Development Control
Ribbles Valley Borough Council

App no: 22.0456

Address: 3 Croft Barn Backridge Farm Twitter Lane Waddington

Proposal: Regularisation of unauthorised change of use from Class E to motor vehicle workshop including selling and displaying motor vehicles externally

Drawing number 02A

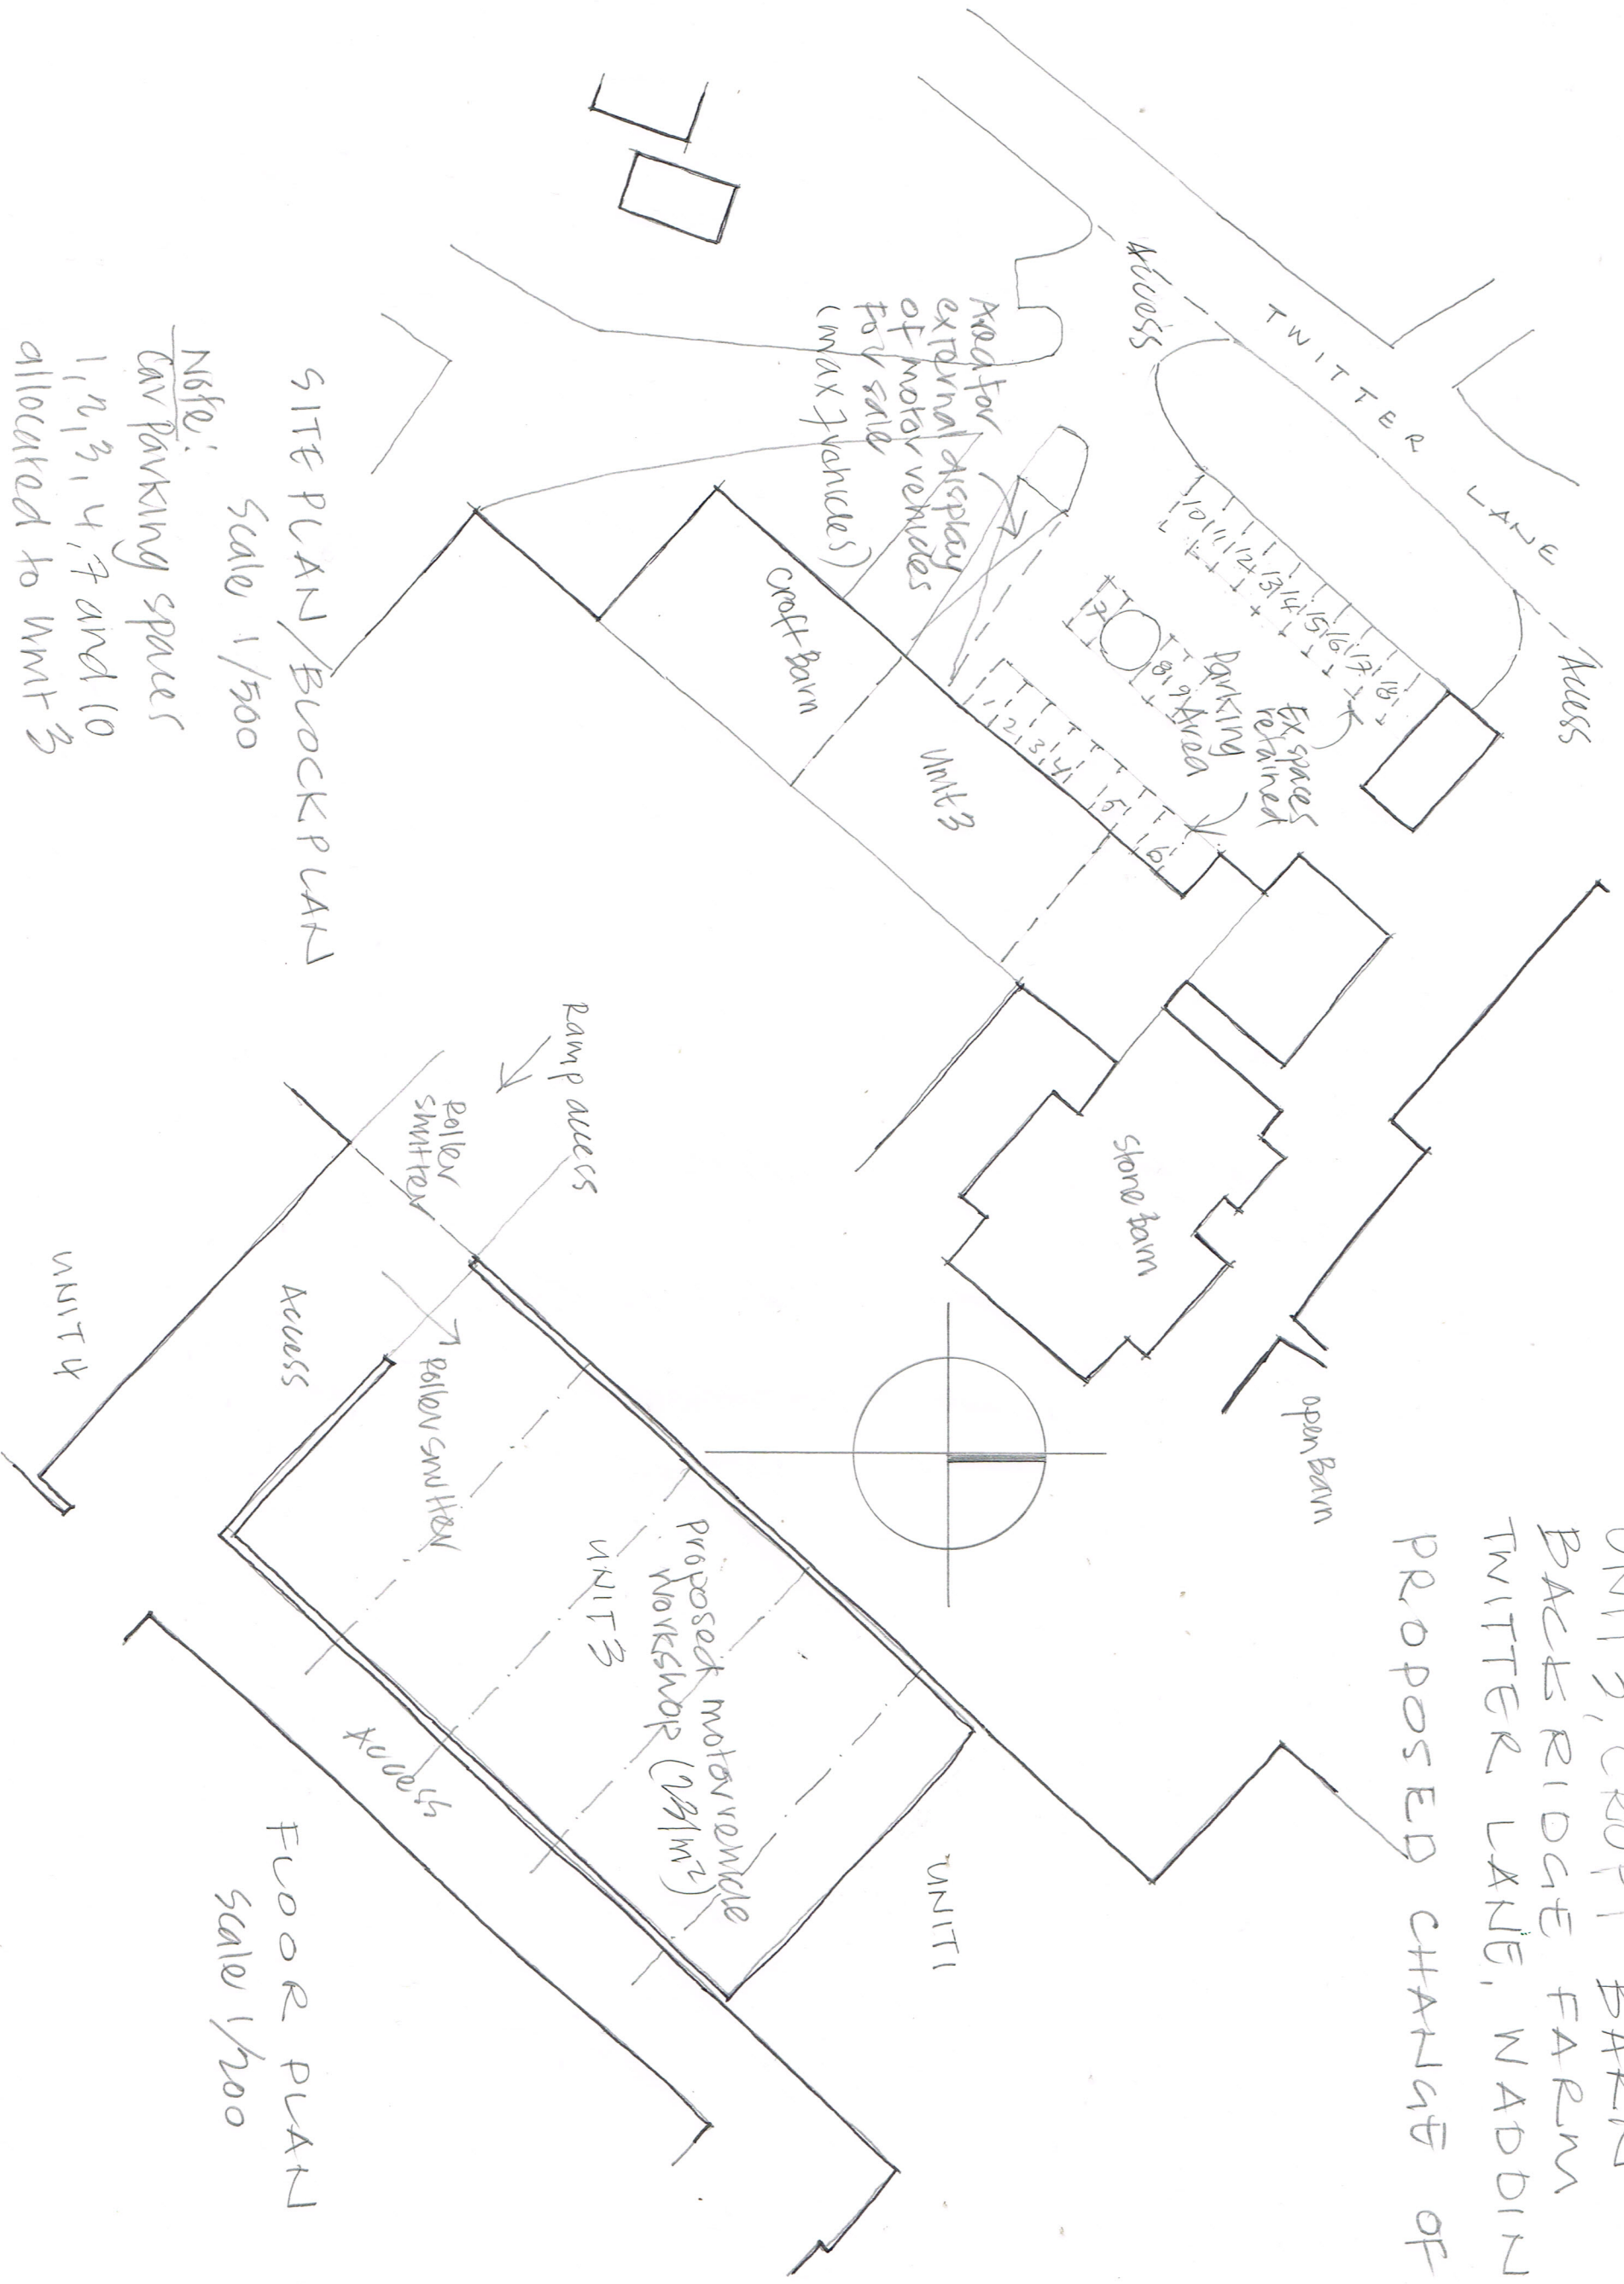
The 231sqm floor area would require 5 car parking spaces in accordance with the parking standards (1 space per 50 sqm) plus a customer car parking space for the external car sales element, totalling 6 spaces. These spaces need to be shown on the site plan within the red edge.

The external car sales spaces need to be clearly shown on the site plan and individually marked.

The car parking spaces being shown on the site plan are within the red edge.
